Recommendation Report for Planning Permission for Works or Extension to a Dwelling

REF NO: BE/132/20/HH

LOCATION: 394 Chichester Road
 North Bersted
 Bognor Regis
 PO21 5BU

PROPOSAL: Part two storey part single storey rear extension and open oak frame porch

A102b

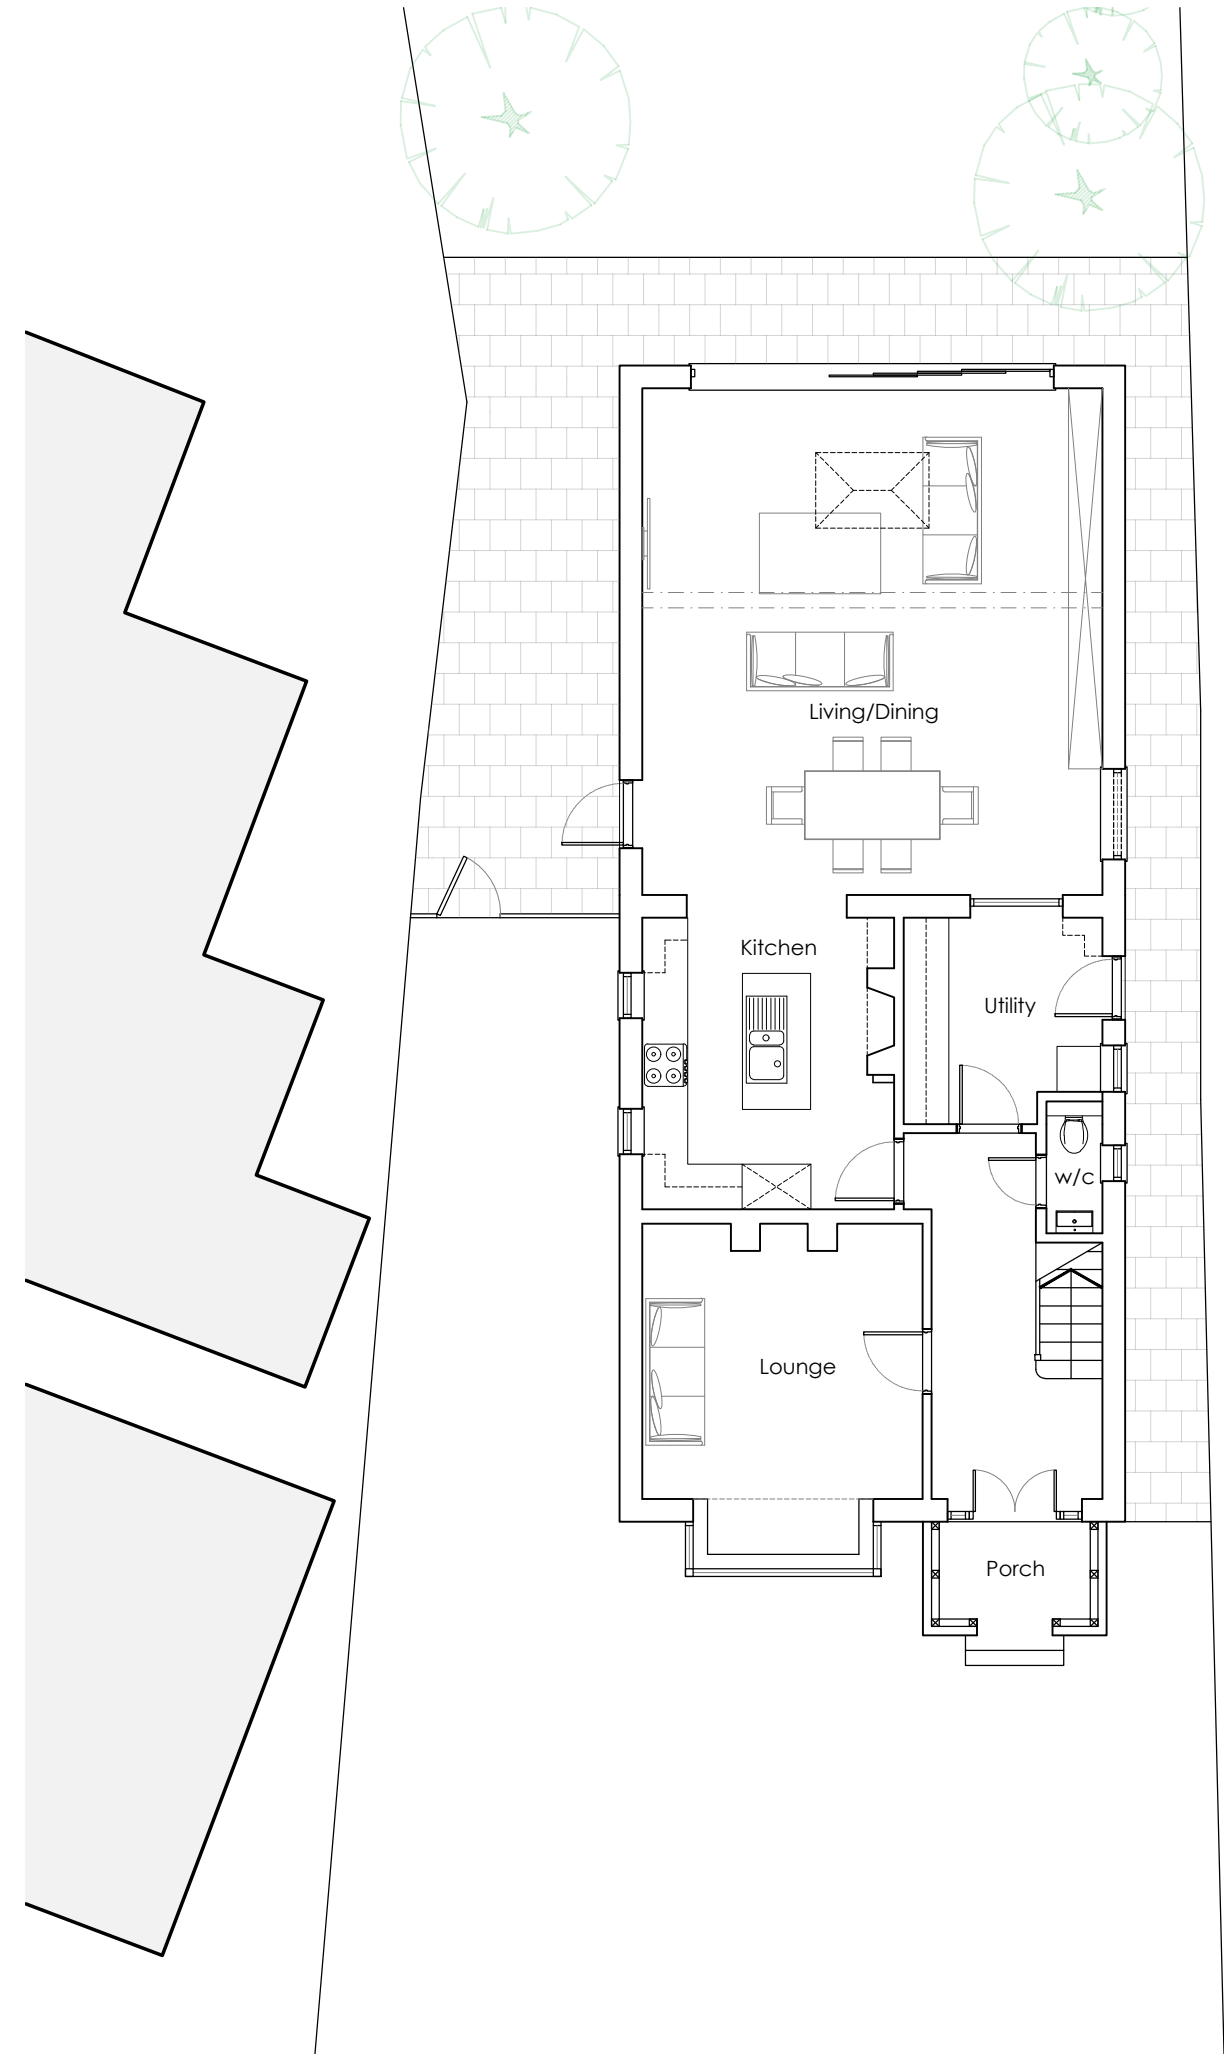
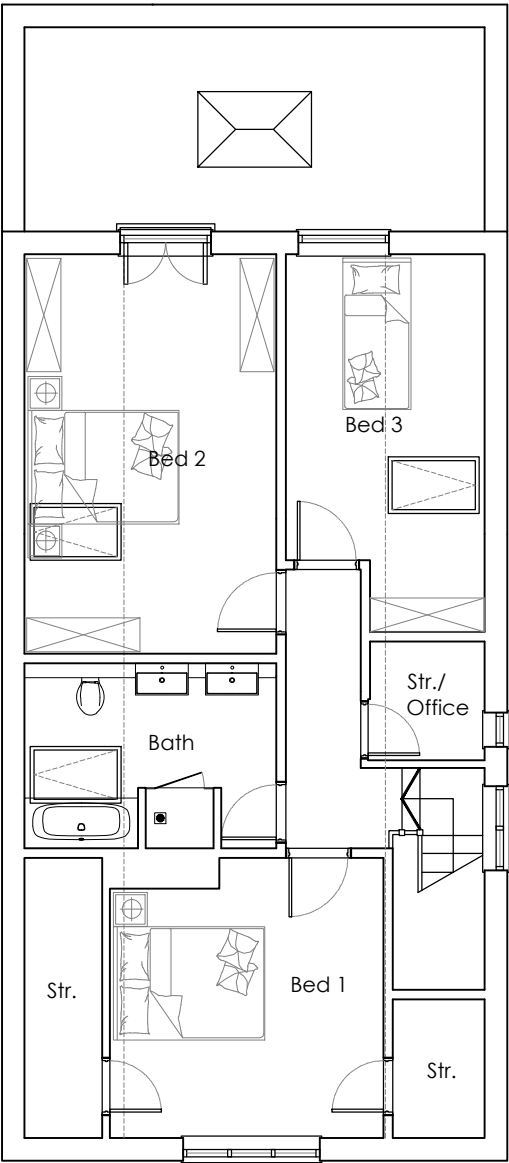
Whilst the extensions will add bulk to the rear due to the siting, with approximately 2.7m to the north western boundary and just under 1m to the south eastern it is not considered to appear overbearing or give rise to adverse overshadowing upon neighbouring properties. The first floor extension is also not considered to impact a 45 degree angle when drawn from the first floor windows closest to the boundary.

There will be an additional ground floor window to the side elevation however with boundary treatment and planting in place, at single storey level it is not considered to result in adverse overlooking. Doors will open out onto the rear garden.

To the first floor there will be 2 rear facing windows, one serving as a juliet balcony however a minimum of 18.7m is retained to the rear boundary and not considered to give rise to additional adverse overlooking.

A202b

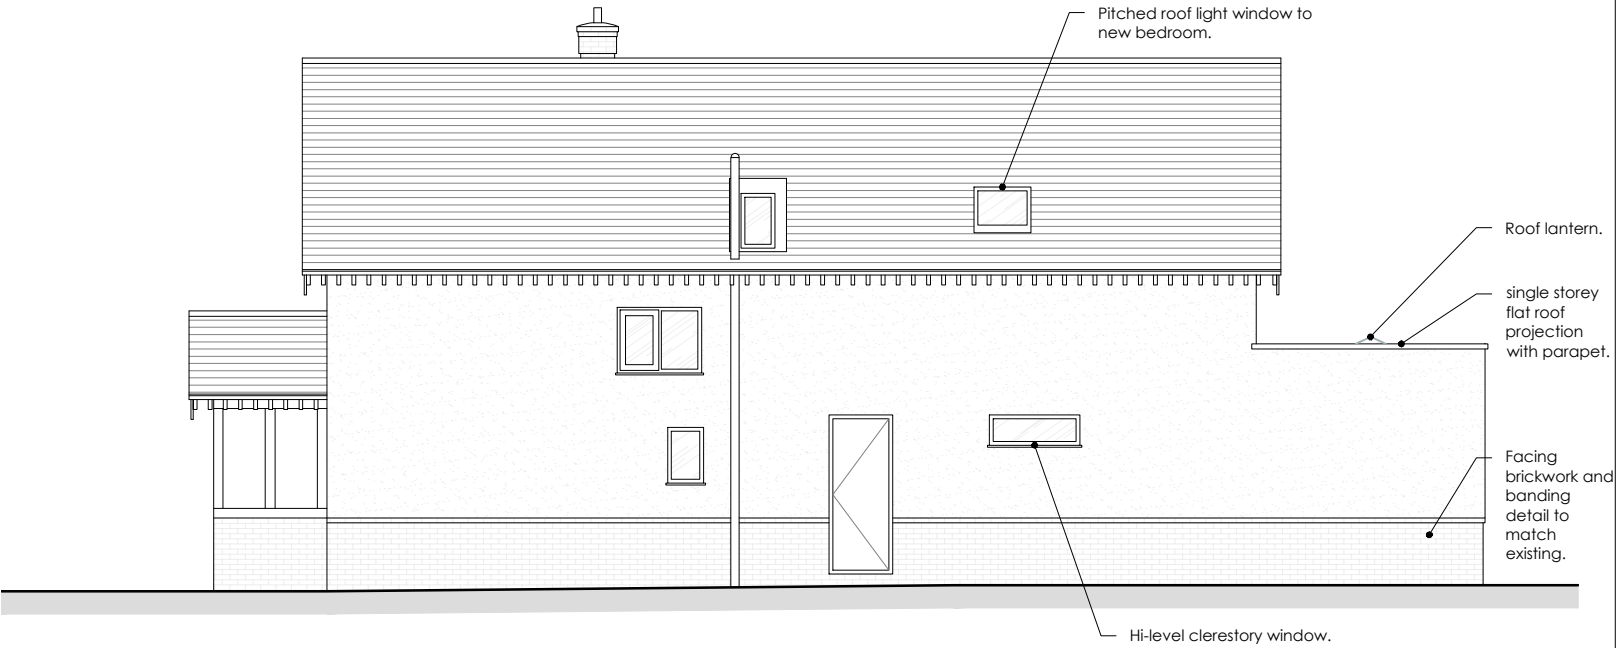
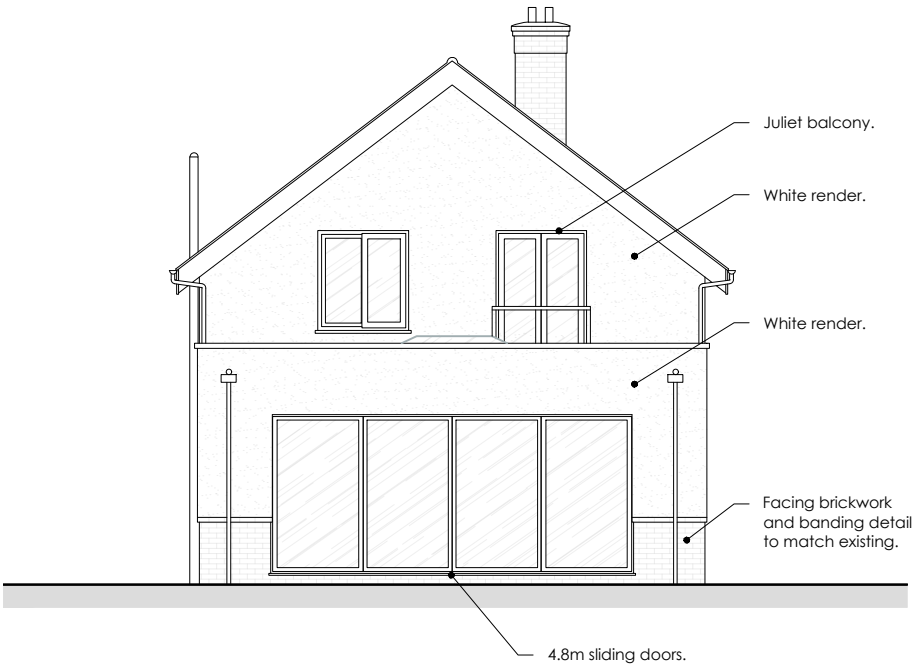
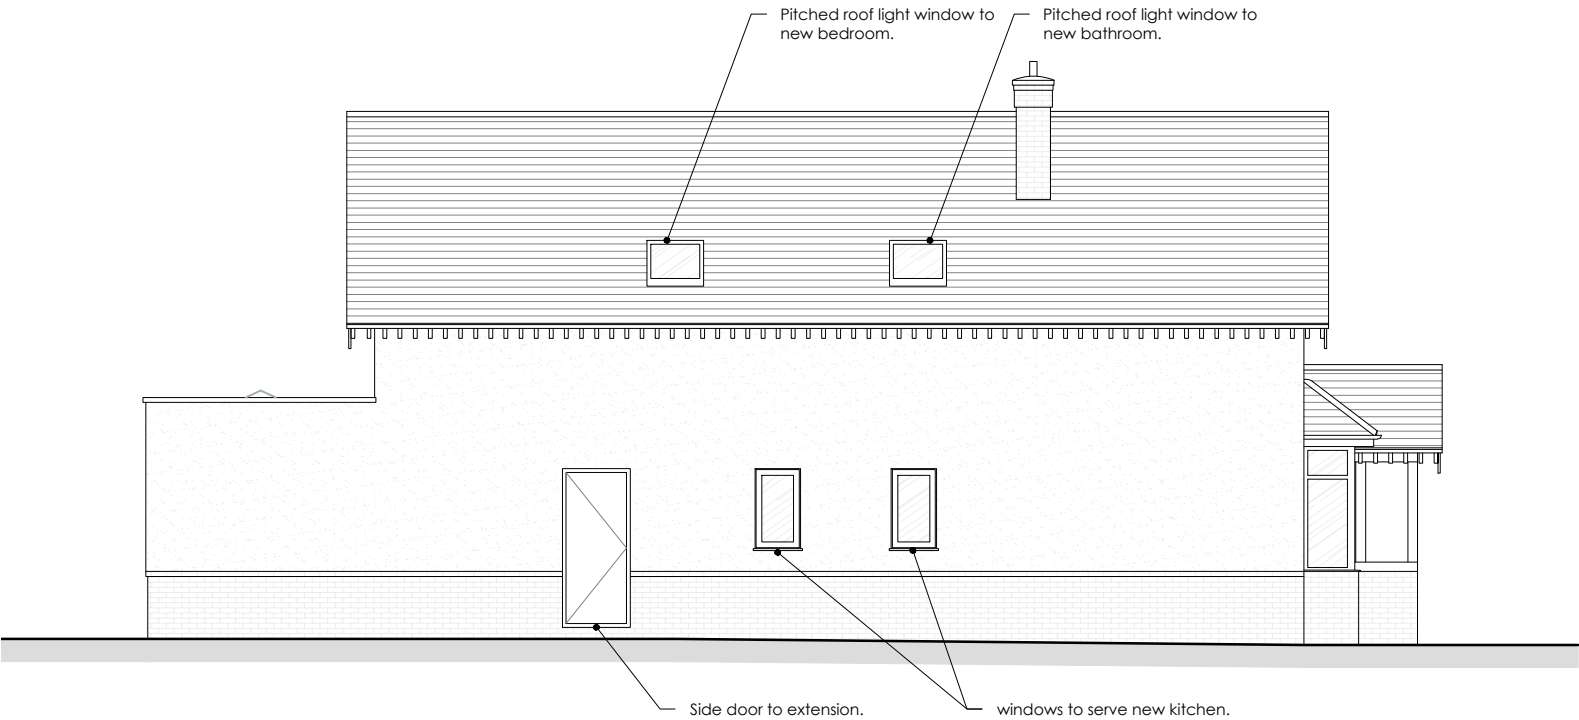
A porch will also be constructed to the front of the property. This will have a depth of around 1.5m with a pitched roof to 3.5m. This does not appear unduly dominant upon the front elevation and retains around 11m to the front boundary.

The addition to the rear will extend at two storey depth for 4m, it will then reduce to single storey for a further 3m. The two storey addition will extend from the ridge line of the host dwelling. The single storey addition will have a height of 3.15m with a flat roof.

Reason: To comply with Section 91 of the Town and Country Planning Act 1990 (as amended).
- 2 The development hereby approved shall be carried out in accordance with the following approved plans
 - Location Plan
 - Block Plan
 - Proposed Elevations - Rev B
 - Proposed Floor Plans - Rev B
Reason: For the avoidance of doubt and in the interests of amenity and the environment in accordance with policy D DM1 of the Arun Local Plan.
- 3 The flat roof area hereby permitted shall not be used as a balcony.

Reason: In the interests of the amenities of adjacent residential properties in accordance with D DM1 and D DM4 of the Arun Local Plan.
- 4 **INFORMATIVE:** Statement pursuant to Article 35 of the Town and Country Planning (Development Management Procedure)(England) Order 2015. The Local Planning Authority has acted positively and proactively in determining this application by assessing the proposal against all material considerations, including planning policies and any representations that may have been received and subsequently determining to grant planning permission in accordance with the presumption in favour of sustainable development, as set out within the National Planning Policy Framework.
